KIRKLEES METROPOLITAN COUNCIL INVESTMENT & REGENERATION SERVICE

DELEGATED DECISION TO DETERMINE PLANNING APPLICATIONS

Reference No:	2025/62/90099/W
Site Address:	7, Bradley Grange Gardens, Bradley, Huddersfield, HD2 1QX
Description:	Erection of single and two storey extensions to the side, front and rear and formation of extended access including associated works
Recommending Officer:	Molly Storer

Officer Report.

PROPOSED REAR ELEVATION Scale 1:100

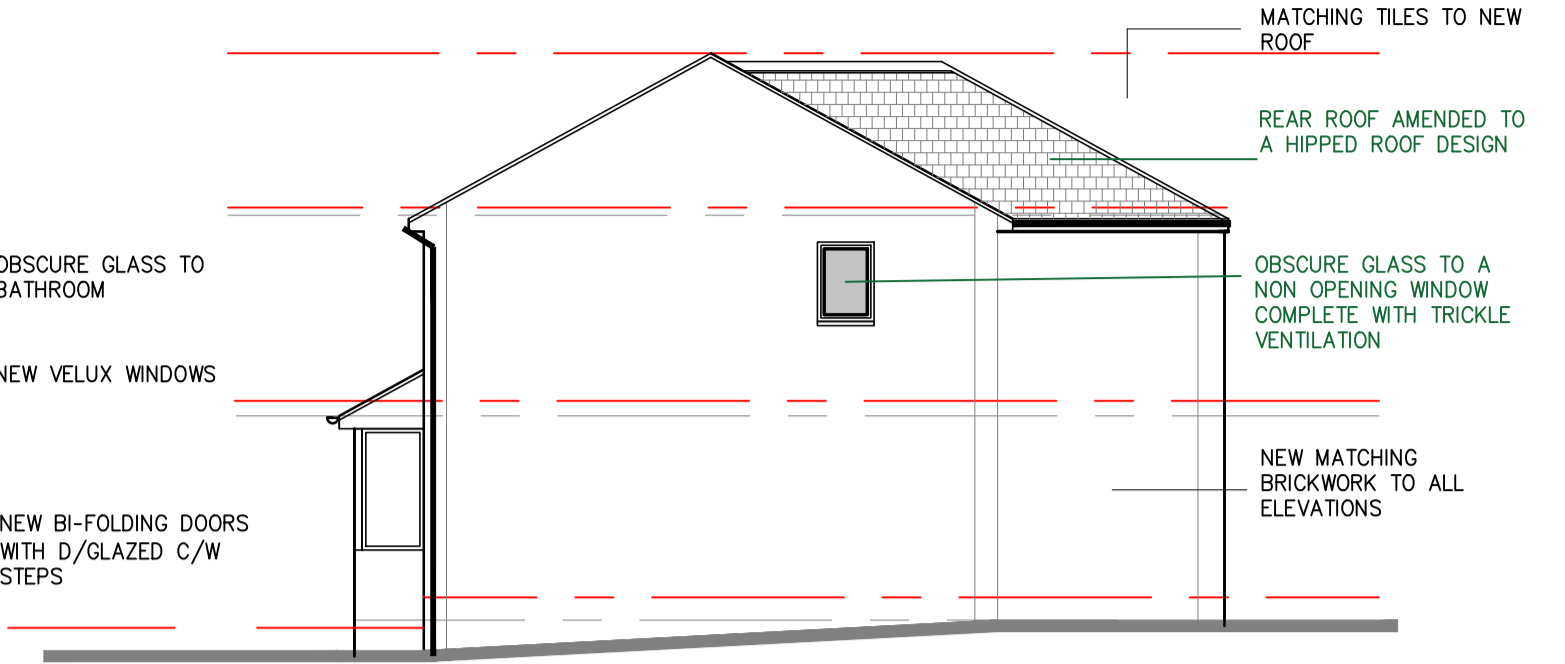
Whilst it is noted that the footprint of the dwelling would significantly increase, these additions are now predominantly to the side and rear. The amended plans show the first floor front element removed and the first floor element of the side extension set back behind the front elevation. This means that the two storey side extension will now comply with the SPD as the first floor element is set back by 1m and set down from the roof ridge of the existing house. It is also set in from the side boundary by 1m.

The design would still see a single storey front element and the single storey side element would extend to align with this. However, this design has overcome previous reasons for refusal as it is now limited to single storey and would not extend beyond the existing canopy to the front. It would also be in-line with the existing bay window to the front of the property. Therefore, although front extensions are usually not acceptable, on balance it is considered in this instance that the front element is now of a design which is subservient to the original dwelling would not harm the character of the wider street scene.

The two storey rear extension would still only maintain a gap of 1m to the boundary with No.9 but has been reduced in size from the previous refusals. It would not only project from the rear wall by 3m but would be set down by 0.5m with a hipped roof. Therefore, although it does not comply strictly with the SPD, it will not extend further than the rear at number 9 where it is within 1.5m of the boundary and where it extends further to the rear than number 7, the two storey rear element is at a separation distance of over 4m.

In addition, officer's note that the majority of the proposed two-storey side extension would sit adjacent to the solid side elevation of No. 5. Whilst a length of approximately 3.85 metres of the two-storey side extension would project beyond the brick rear elevation of No. 5, it would retain a separation distance of 2.6 metres from the siting of the conservatory to the rear of this neighbouring property and would not cut a line of 45-degrees across the glazing which serves the conservatory, or the closest first floor windows. Therefore, for these reasons, it is not considered that the proposed two-storey side extension would result in undue impacts of overbearing or overshadowing towards No. 5.

With regards to the rear elements, the design has been reduced from the previous refusal from 4m to 3m. Although the single storey lean-to rear extension would not be compliant with the 45-degree rule, as set out under Key Design Principle 5 of the House Extensions and Alterations SPD, it is noted that the single storey rear element will have a limited projection, eaves and overall height. Furthermore, the two storey rear extension now is of a hipped roof design to further limit overall bulk and massing to this neighbour.

The proposal includes some glazing to face directly towards No. 5 Bradley Grange Gardens. This to serve bathrooms, a utility room and the kitchen. Upon any grant of approval, a condition is recommended to be imposed to obscure glaze all these windows to the side elevation, for reasons of protecting residential privacy and mitigate undue levels of overlooking.

The proposed two-storey rear extension would be separated from the shared boundary with No. 9 by approximately 1m and due to the reduction in projection from the previous proposal the rear extension would not project beyond the rear elevation of No.9.

It is also noted that the proposed two-storey extension would not cut a line of 45-degrees to any habitable room windows to the rear of No. 9 and would not extend towards the patio area which serves No. 9, considered to be a primary area of functional outdoor amenity space to serve the occupiers of No. 9. This means that there would be no significant overdue overshadowing/overbearing impact to this property.

The only glazing proposed to the side elevation of the dwelling adjacent to No. 9 is a bathroom window. This would therefore likely be obscure glazed and as such, would not impact upon residential privacy with regard to overlooking. To ensure appropriate levels of residential amenity would be achieved, upon any grant of permission, a condition is recommended to be imposed to ensure this window be obscure glazed and non-opening.

3. All windows within the west side elevation facing No.5 Bradley Grange Gardens upon submitted plan titled 'proposed revised layout' (ref: PDA23-069-004 Rev E) shall be obscurely glazed and be non-opening.

4. All windows within the east side elevation facing No.9 Bradley Grange Gardens upon submitted plan titled 'proposed revised layout' (ref: PDA23-069-004 Rev E) shall be obscurely glazed and be non-opening.
